Comments on the Applicant's D3 Submissions

This document sets out the comments by Cambridgeshire County Council (**CCC**) on the Applicant's Deadline 3 (**D3**) submissions. The table below provides the relevant paragraph or reference numbers.

2.6 Statutory and Non-Statutory Sites or Features for Nature Conservation Plan P03 [\[REP-3-008\]](#)

Dwg no
Figure 7-3a Rev
P02

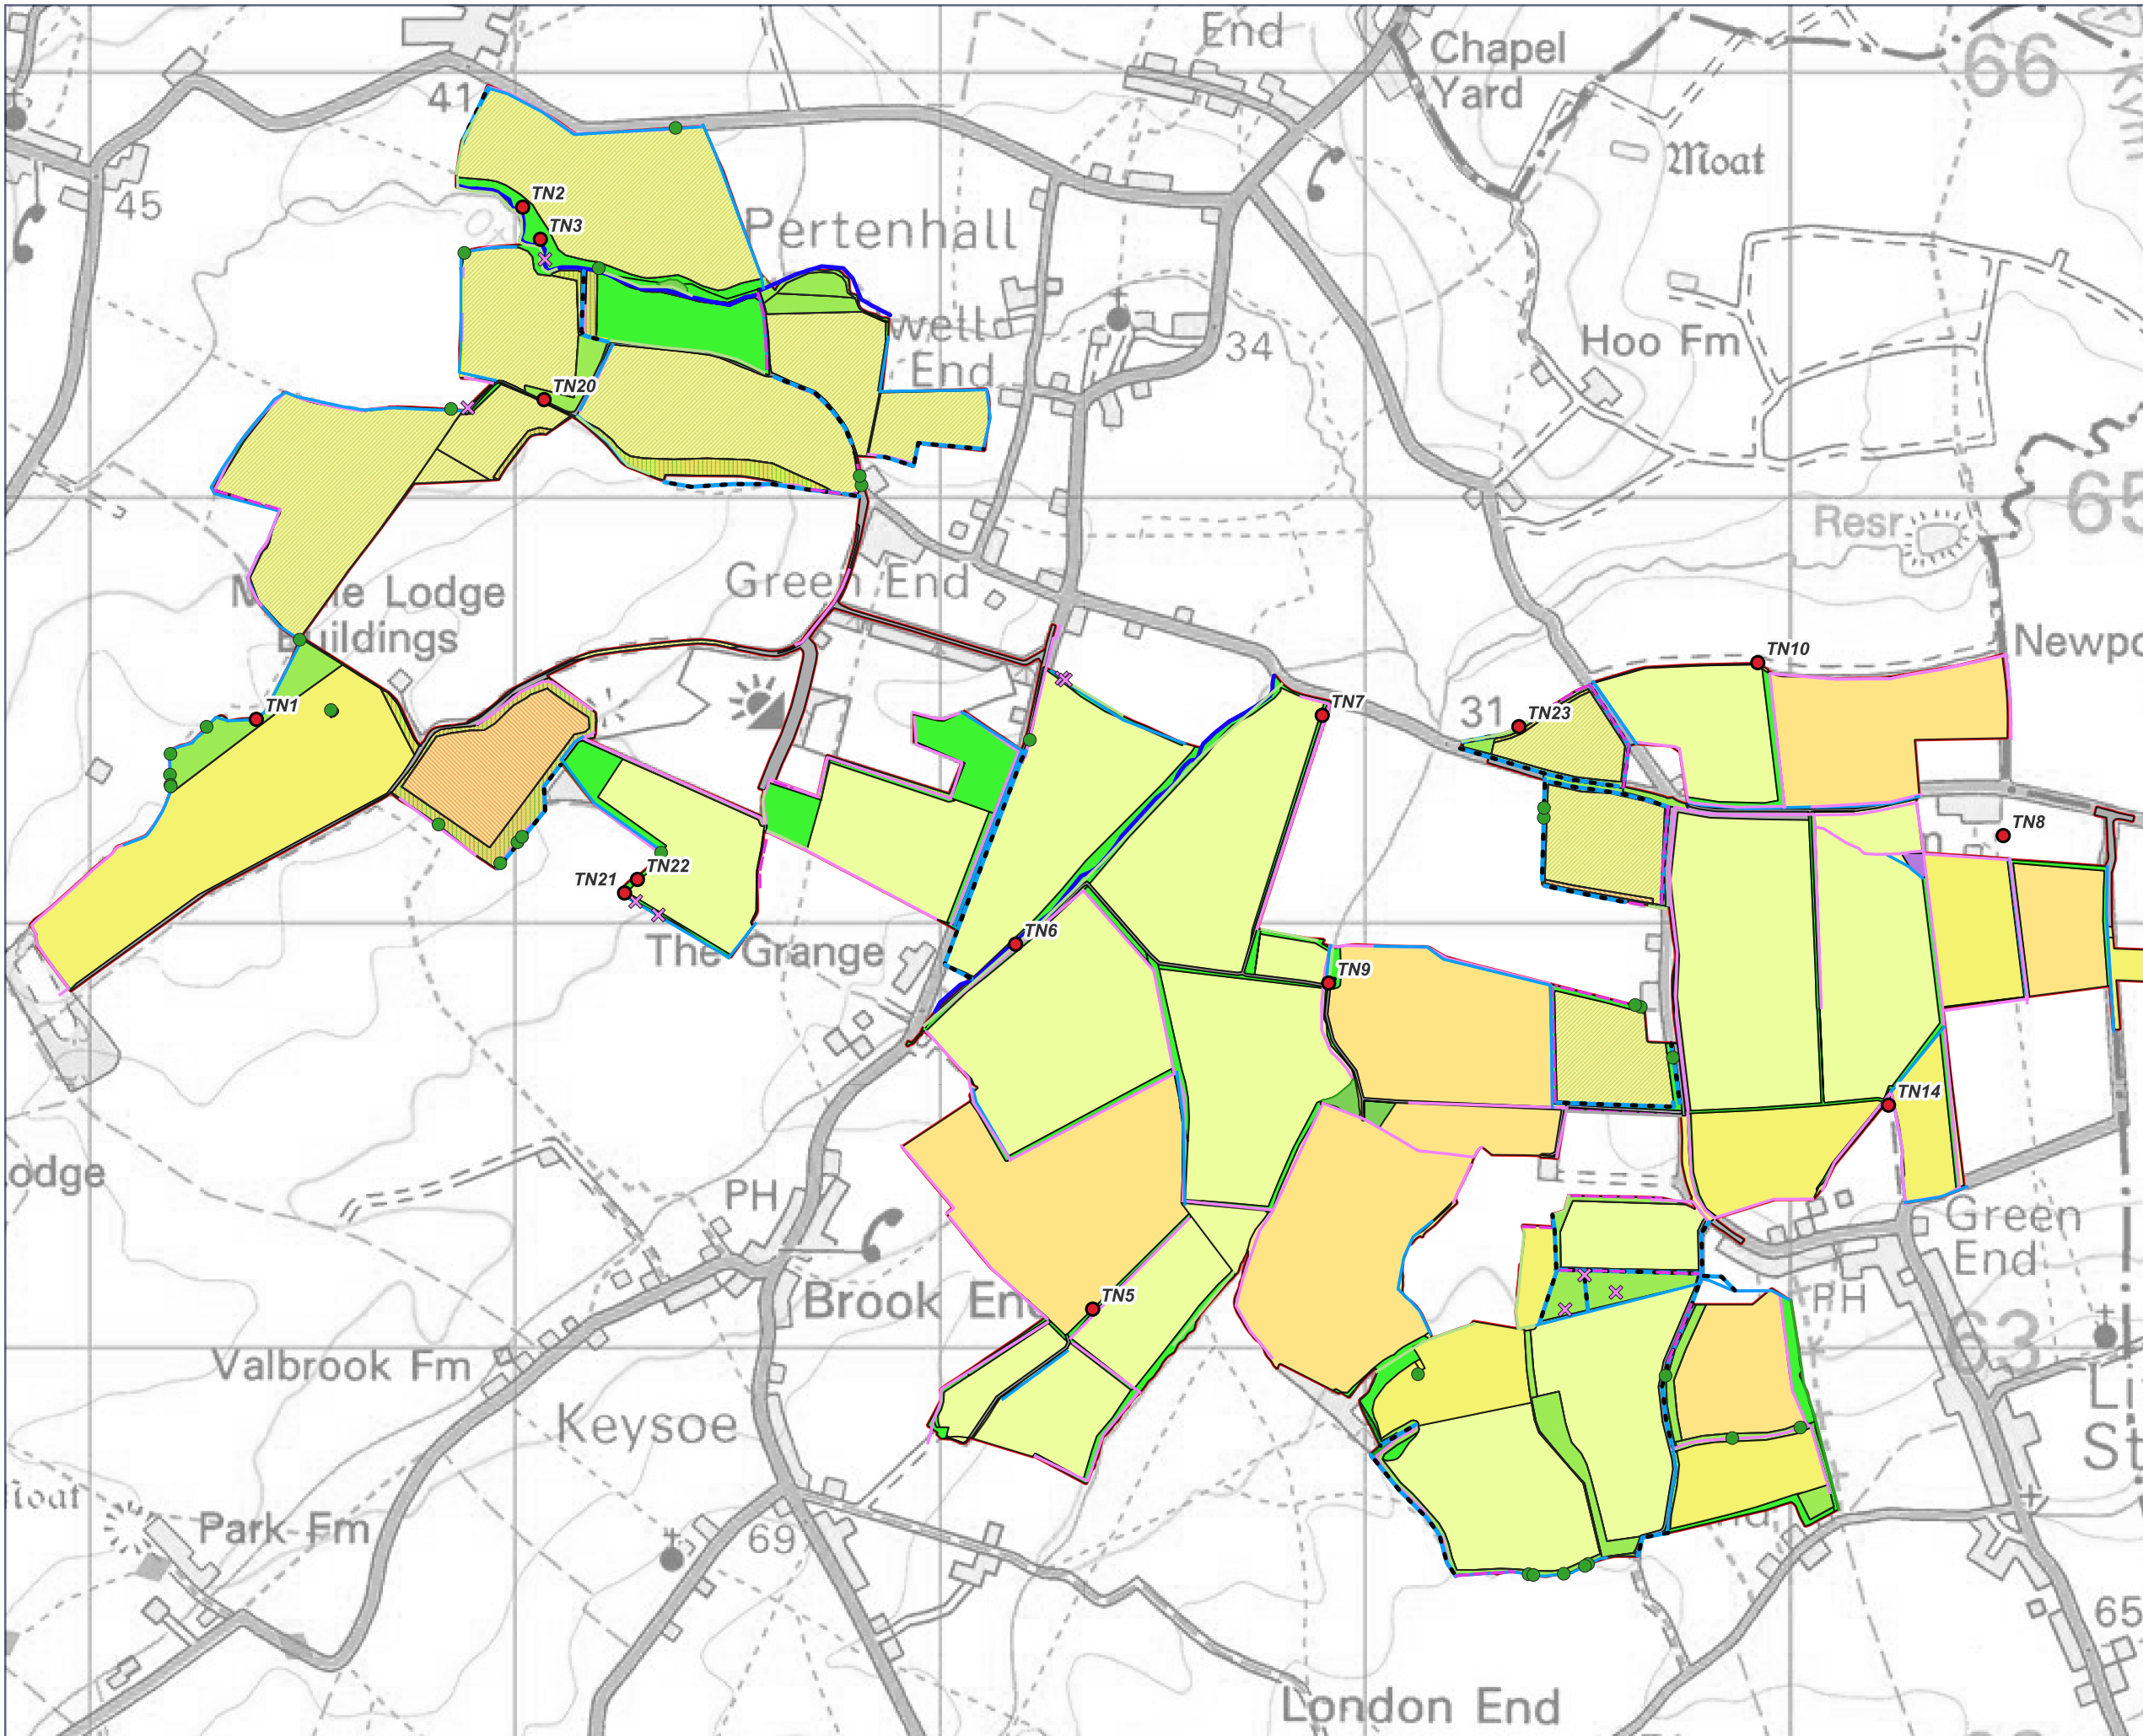
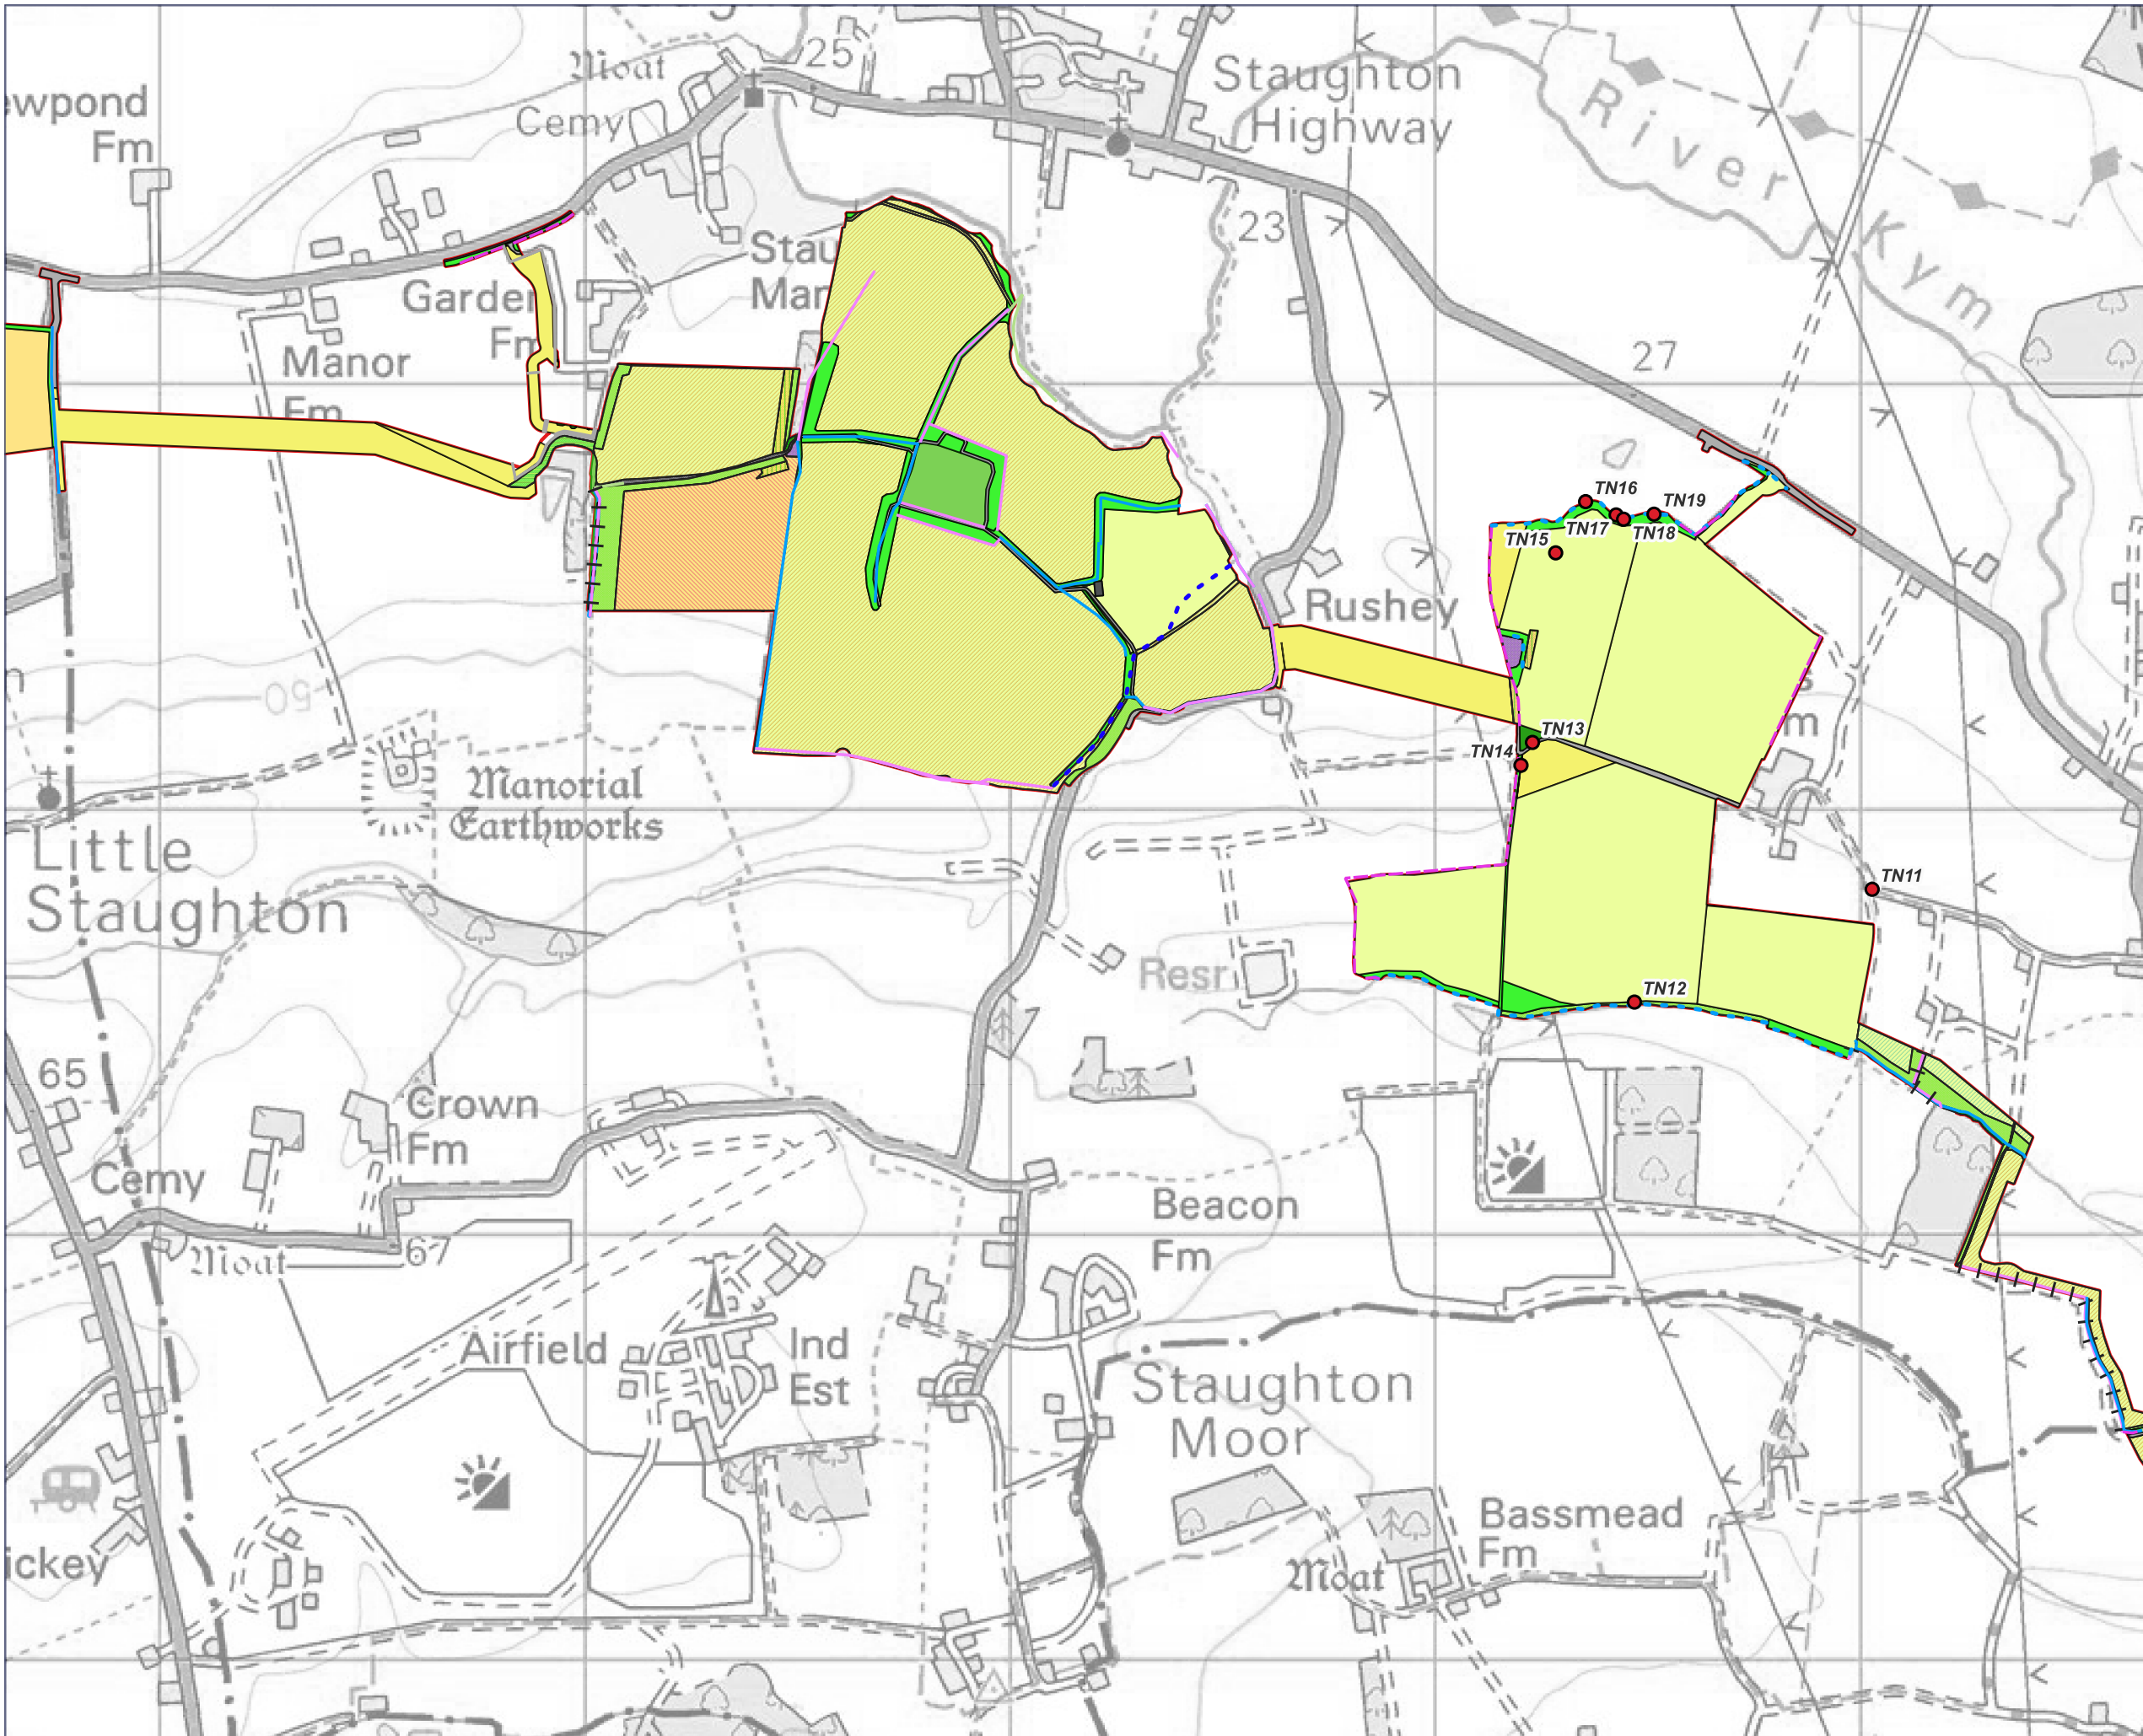
Figure 7-3	Figures 7-3a to 7-3d	No tracked changes version of the document has been provided and therefore, it is difficult to understand what has been altered, since the previous versions. The council assume that all drawings with the original version (P01) indicated on the drawings have not been changed. This suggests that only Figure 7-3 has been updated. The Council seeks confirmation as to what has changed on figures 7-3a to 7-3d
Figure 7-3 – Habitat Survey	Figures 7-3e to 7-3g	The Council welcomes clarification as to the extent of areas of limited survey access.
